# HERTFORDSHIRE BIOLOGICAL RECORDS CENTRE

Ask for: B. Tranter  
Our Ref:  
Your Ref: S6/2012/2608/MA  
Tel: 01992 556155  
Date: 04/01/2013

**Planning application: S6/2012/2608/MA. Nyn Park, Well Road. Replacement boundary fence to Nyn Park Estate.**

TITLE
Proposed Boundary Fence (60f6)

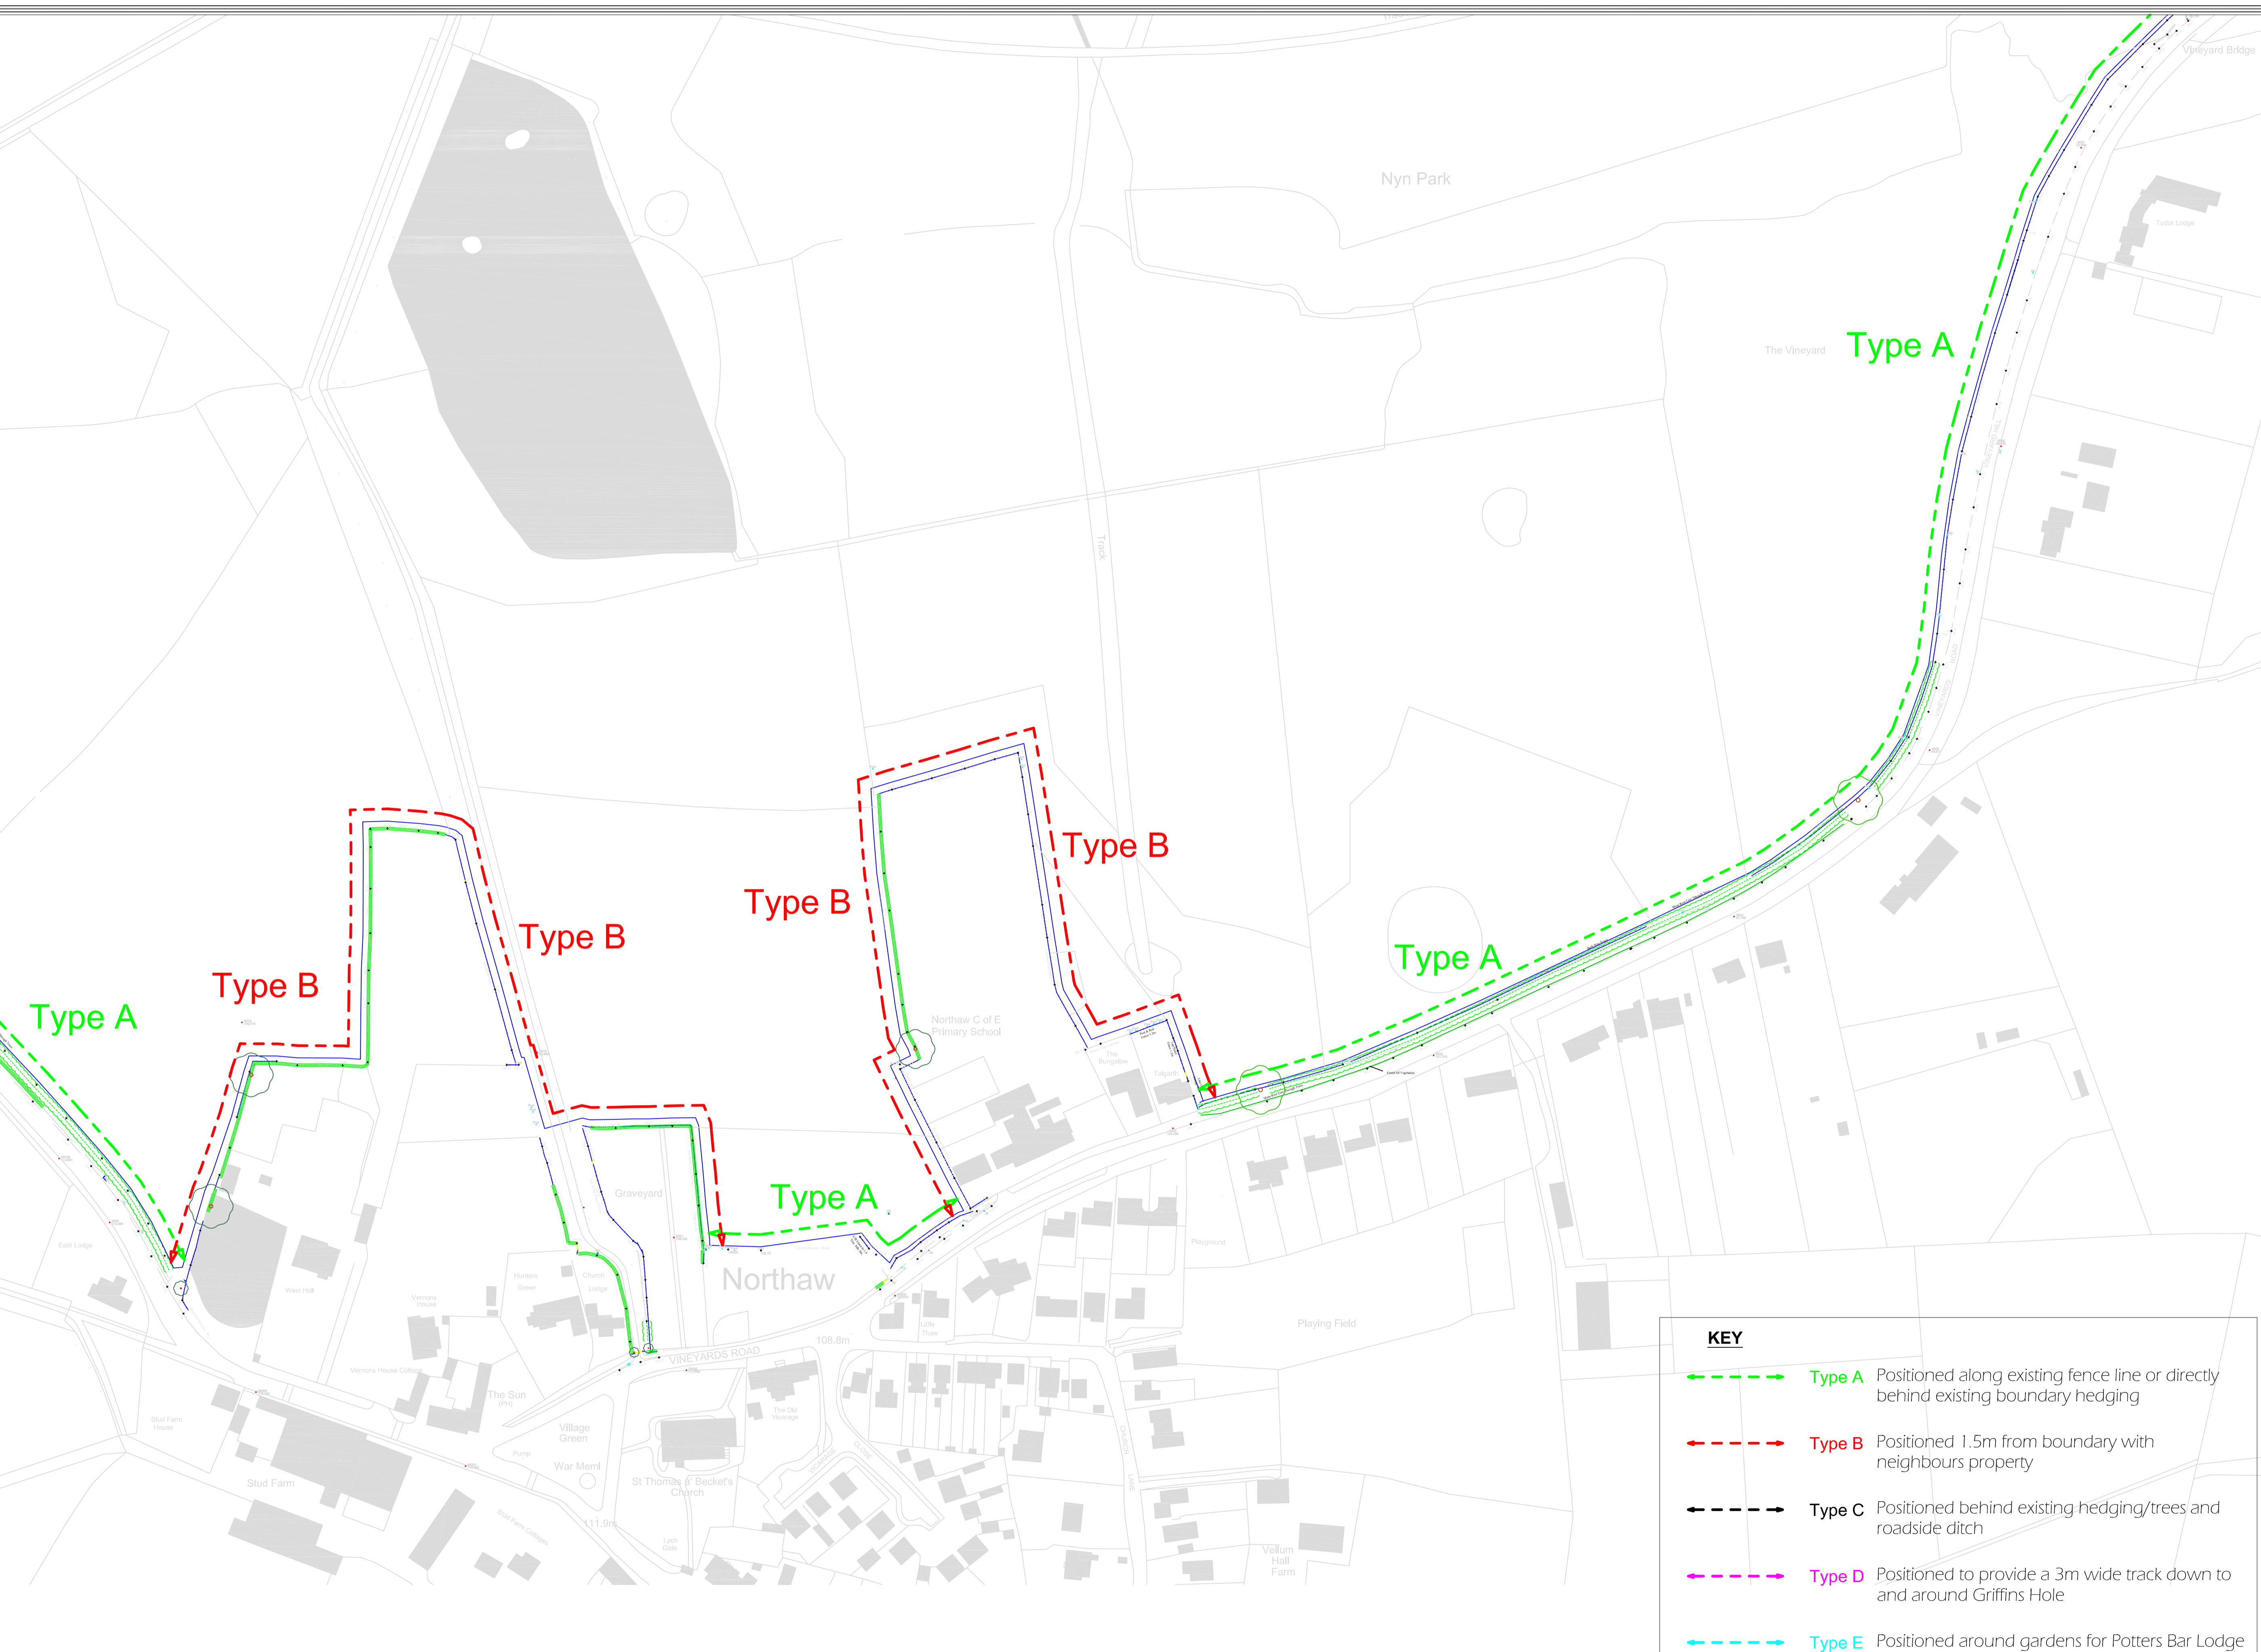
- a) The proposal states that the new fencing is to be set behind the existing hedge lines and that the hedges will be retained and further planted to infill gaps. We are happy with this arrangement as existing hedge lines will be kept and enhanced.

- b) Parts of the existing boundary for example within Well Wood and The Vineyard Wildlife Site, appear to be wooded and without boundary hedgerows. The construction of the fencing will obviously impact these habitats. Works must cause as little disturbance as possible to the ground flora which is often at its most diverse around the perimeter of woodlands. In addition, ancient features such as boundary banks may also be present and these should be protected.

- d) As Well Wood is part of a SSSI Natural England must be informed of the proposals, as the works may impact the SSSI.
